Response to Submissions: Hume Coal Project (SSD 15_7172) and Berrima Rail Project (SSD 15_7171)

Attachment - WaterNSW Comments on the Response to Submissions Report for the Hume Coal and Berrima Rail Projects

Hume Coal Flooding Assessment
Figure 6.1
 100 year ARI flood extent - Operation

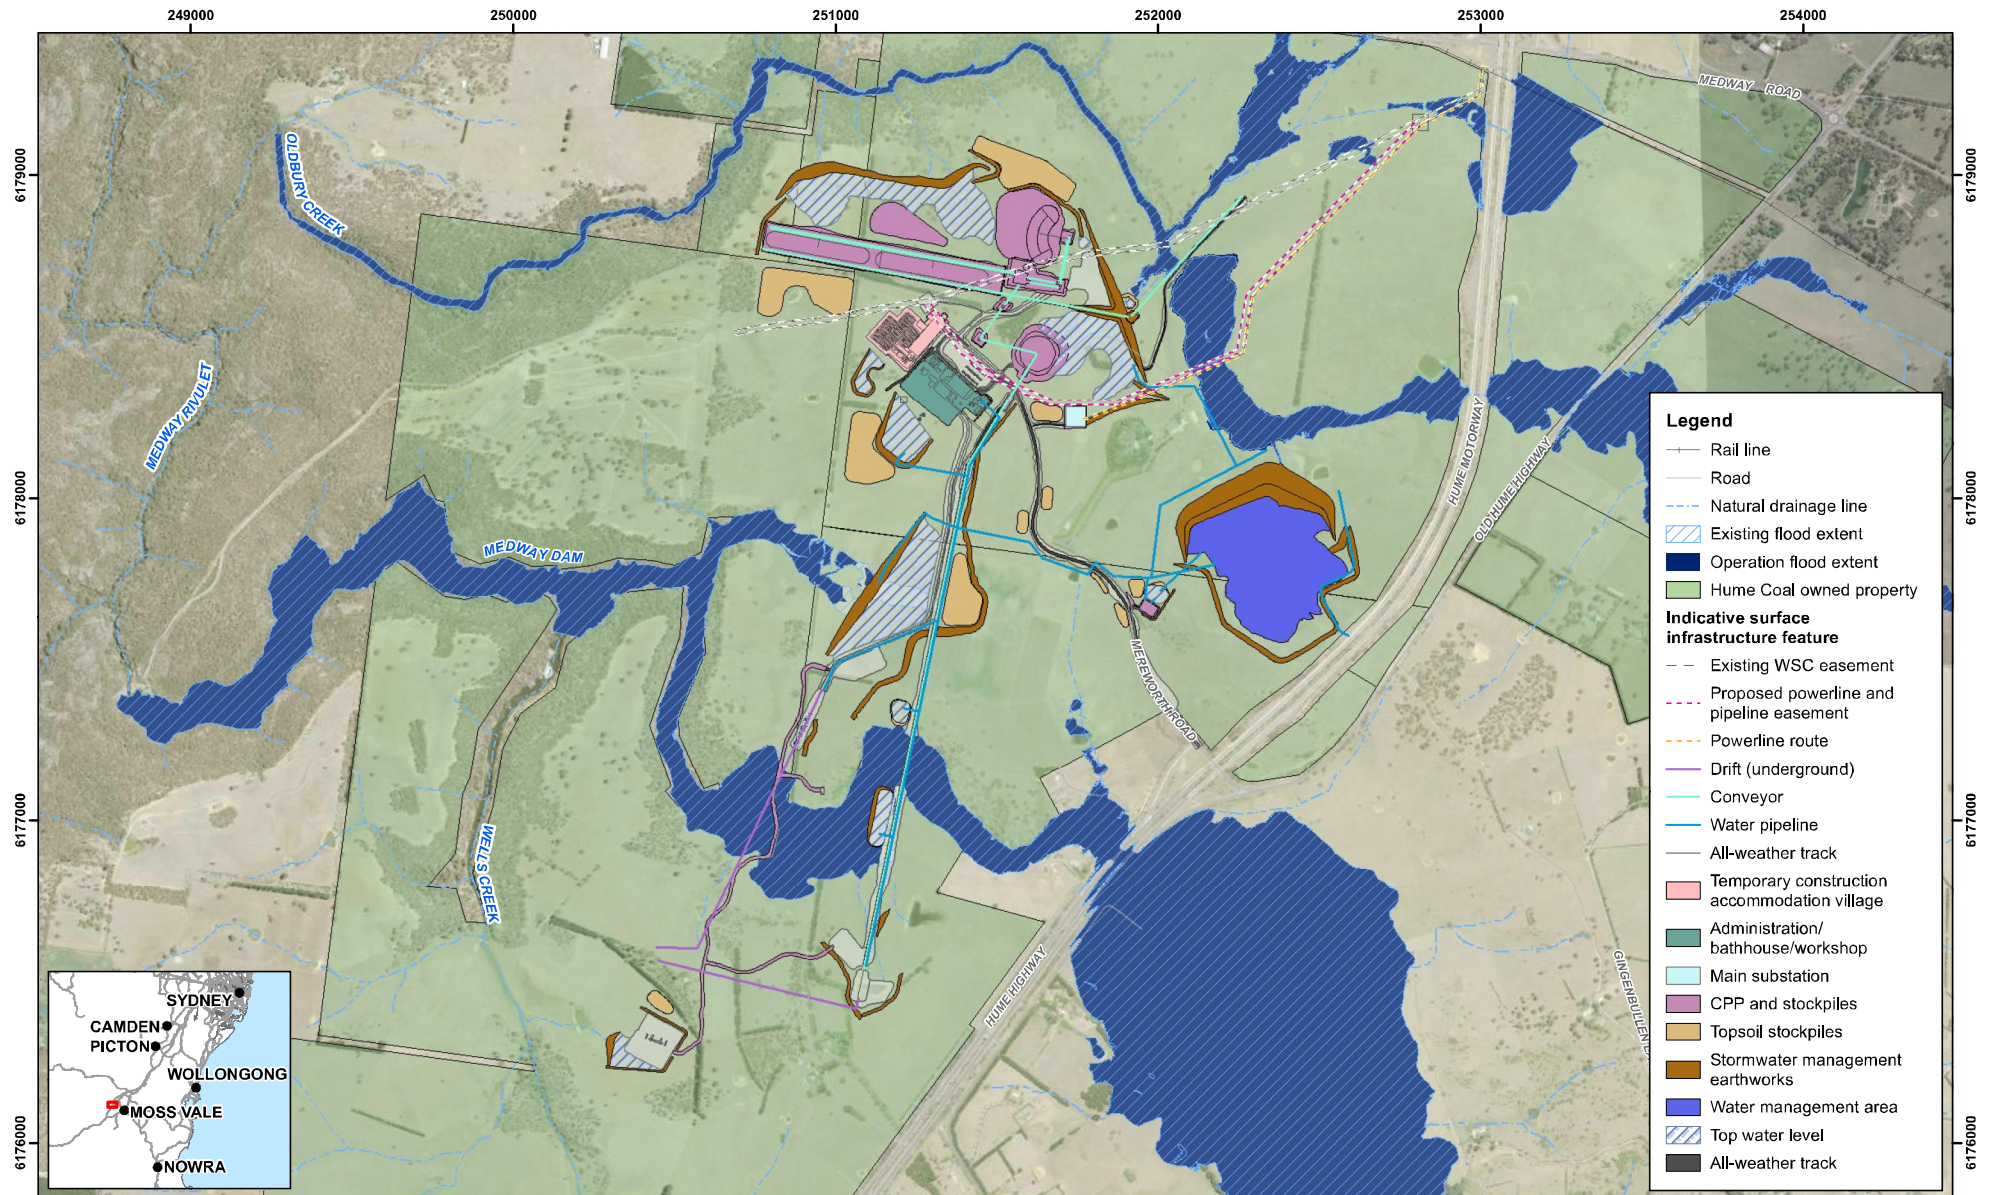
It is noted that mine water dam 06 (MWD06) is proposed within the 1 in 100 year Annual Recurrence Interval Flood Level of Medway Rivulet. To prevent potential failure of MWD06 it is considered that this dam be relocated to above the 1 in 100-year flood level or consideration be given to armouring the exterior walls up to the 1 in 100 year ARI level plus freeboard to prevent scour during a flood event.
